**From:** Martyn White <Martyn.White@arun.gov.uk> **On Behalf Of** Conservation Officer  
**Sent:** 20 February 2025 16:59  
**To:** Planning.Responses <Planning.Responses@arun.gov.uk>  
**Subject:** BR/5/25/PL

## **BR/5/25/PL**

St Julianas Convent Marian Way Bognor Regis PO21 1PA

*Change of Use from Convent (Sui Generis) to Residential Use (C3) for Adults with Learning Difficulties and Autism and minor amendments to external appearance.*

Dwg No. 24056A-P-113 B

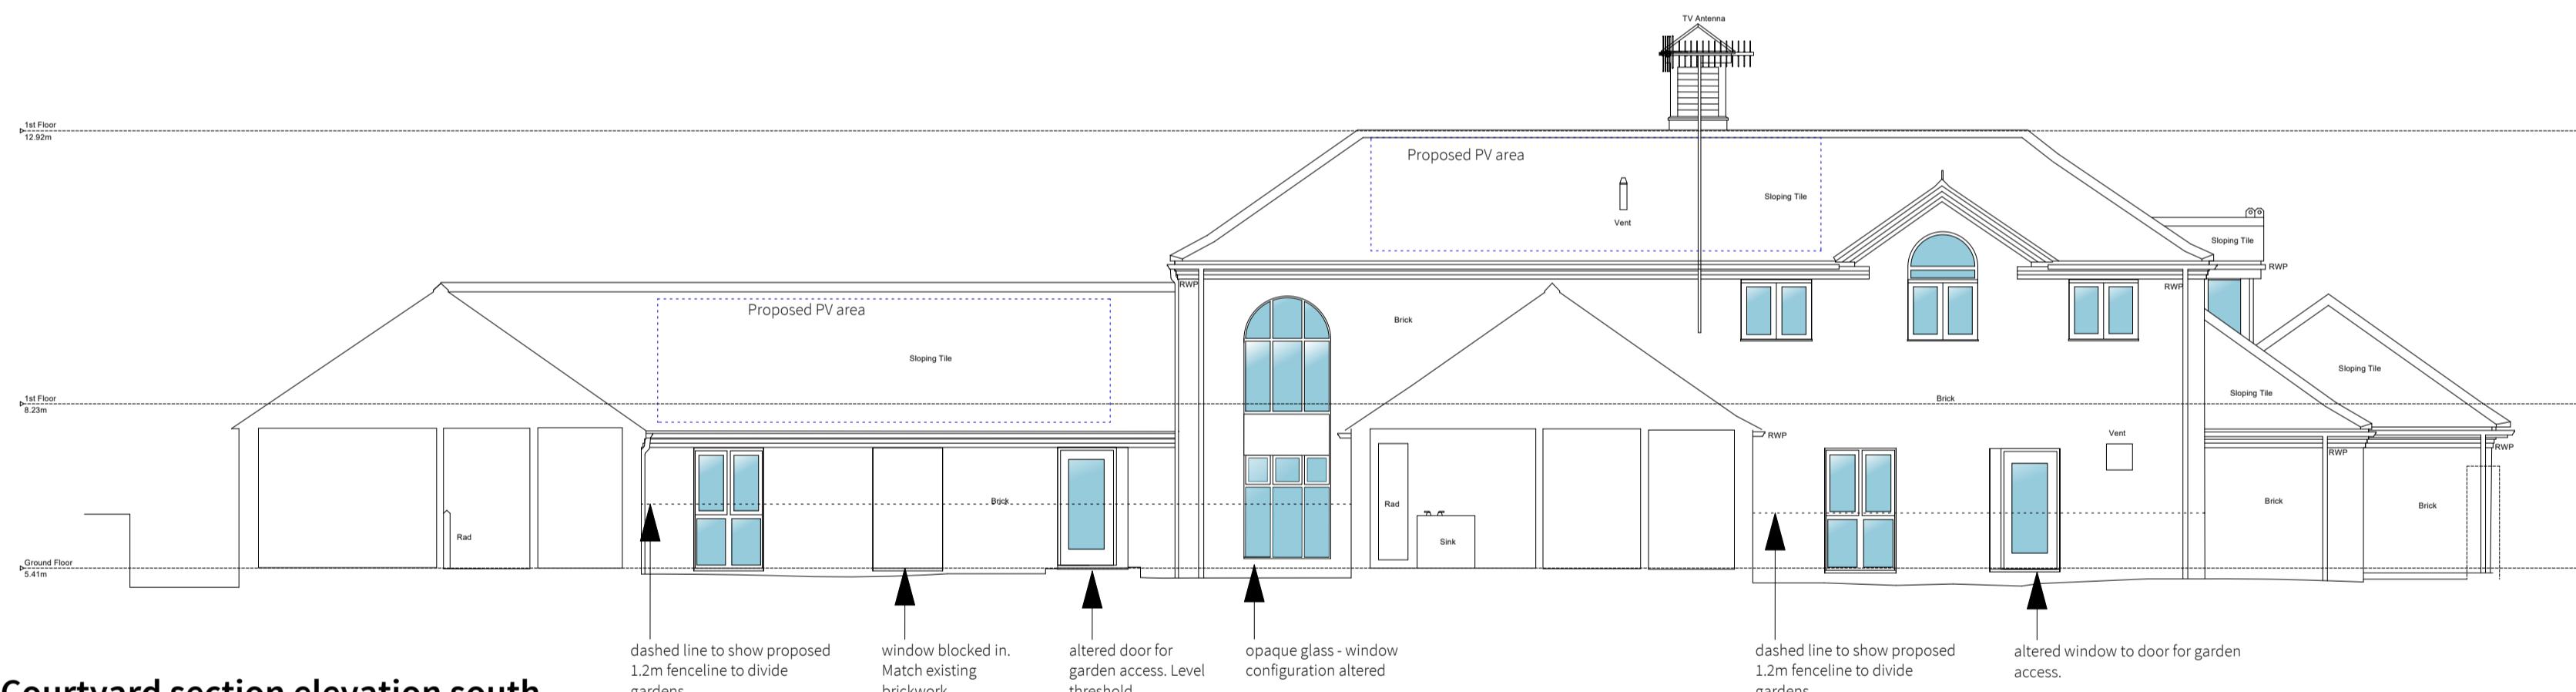
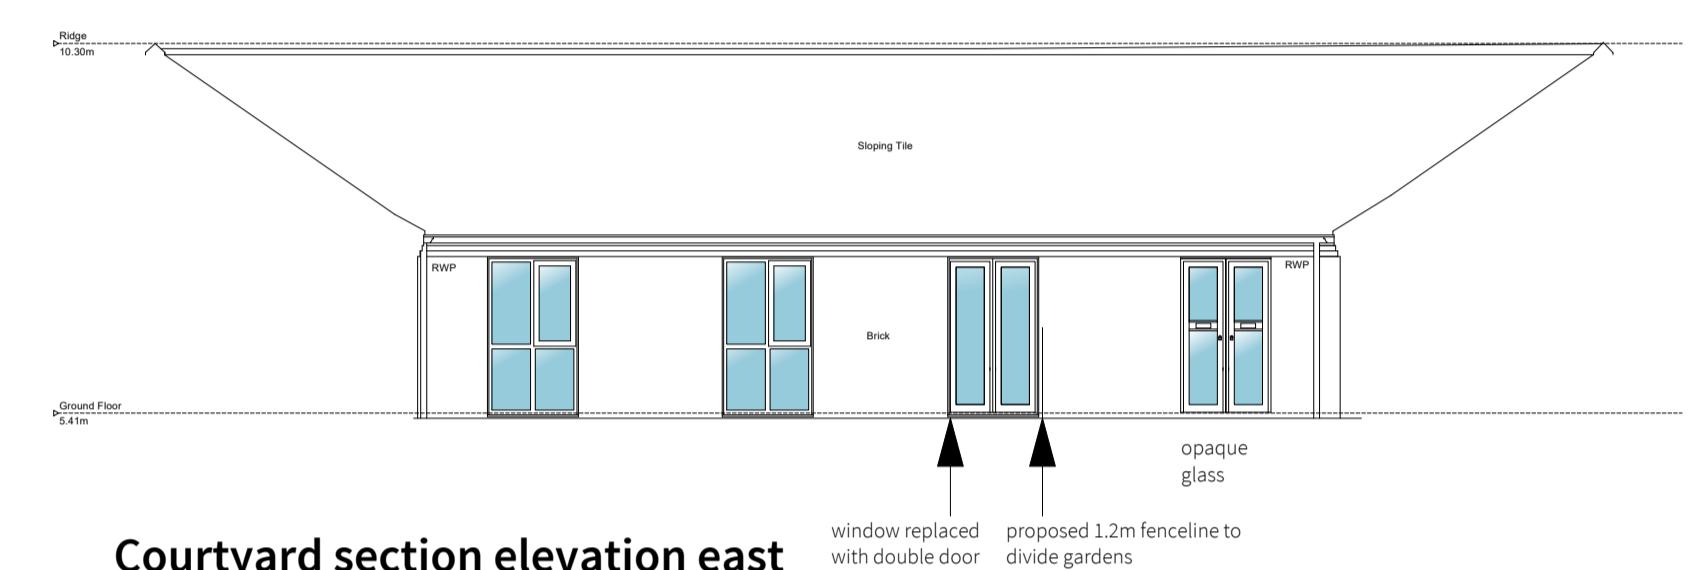
However, I also note from reviewing the proposed plans that the intention is to install solar panels in certain locations. These would be the southern elevations of the building. When I visited the site, it was clear that the part of the building can be seen in the context of the neighbouring listed building, when viewed from Gloucester Road. The solar panels would be located on a slate roof which would help for them to sit more discretely, and potentially reduce their impact. Therefore, on balance, this element is also acceptable. This is partly on the condition that the design is

appropriate for their sensitive context, and that they are removed when they are no longer needed.
